CITY OF ALBUQUERQUE
PLANNING DEPARTMENT
DEVELOPMENT REVIEW BOARD

February 27, 2013

Project# 1005033

13DRB-70448 EXT OF SIA FOR TEMP DEFR SDWK CONST

SITE PLAN OVERALL

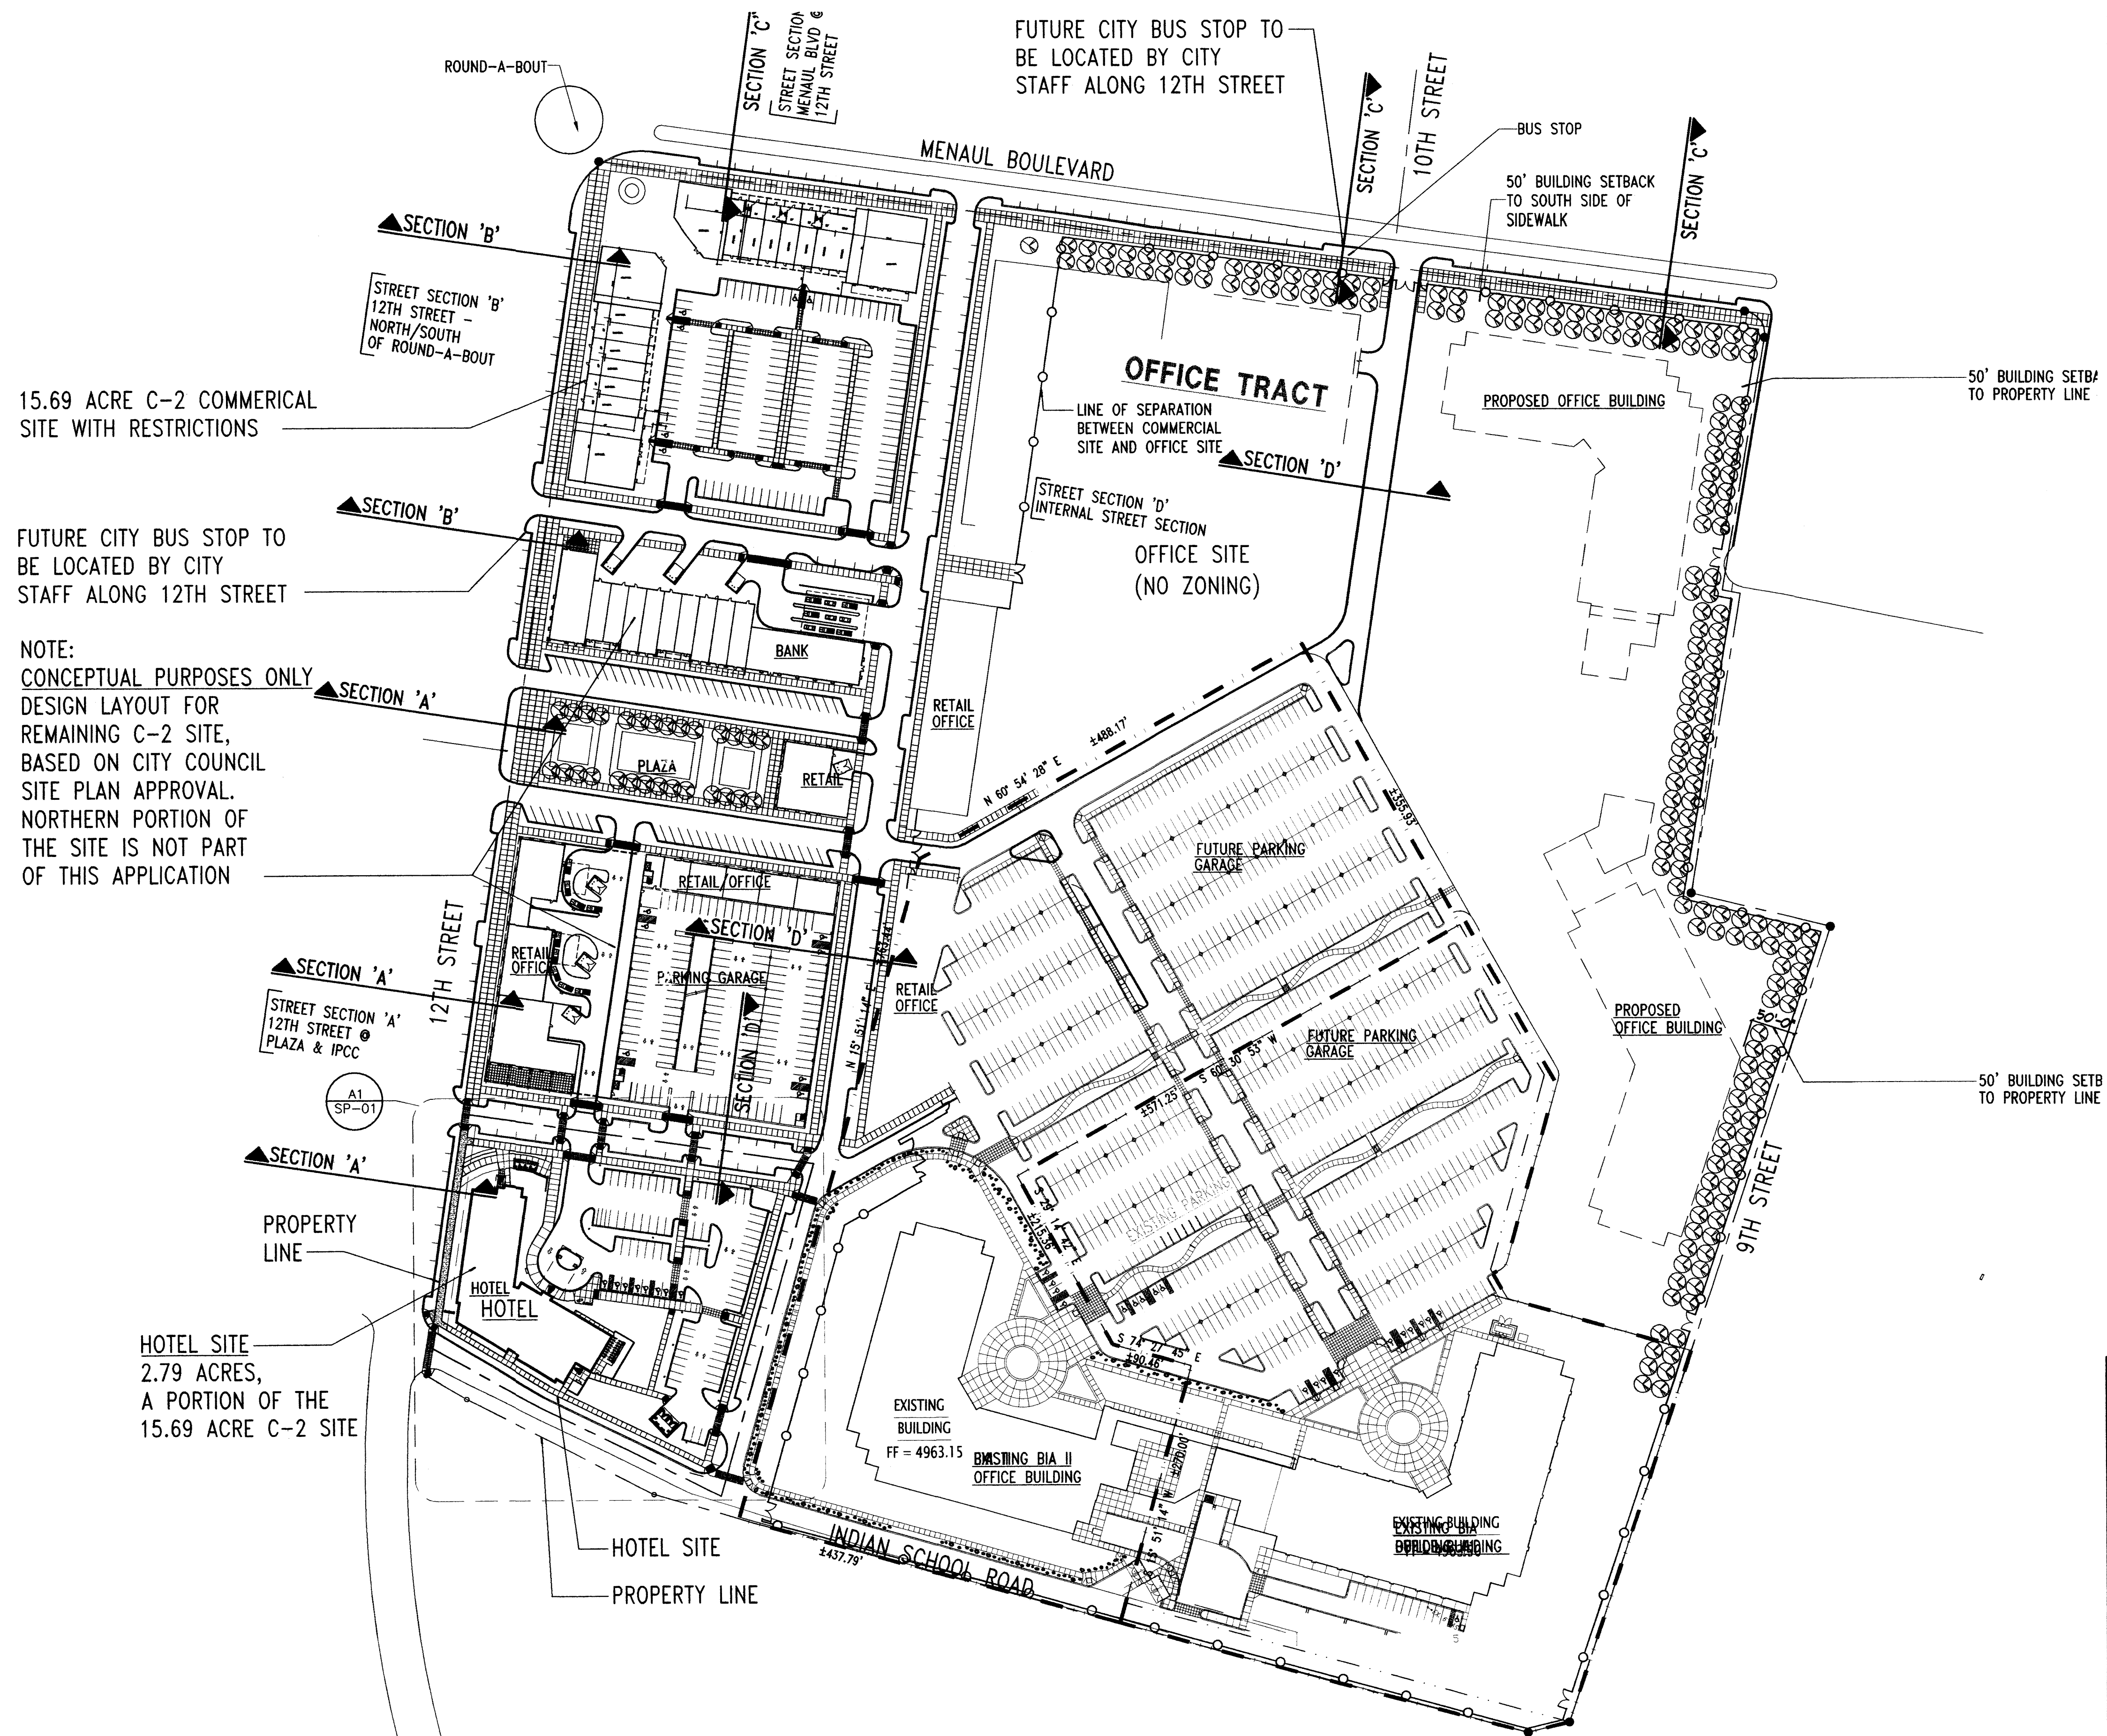
There is a monument sign placed in the location for future sidewalk which is not consistent with the approved site plan and needs to be relocated as a condition of SIA extension.
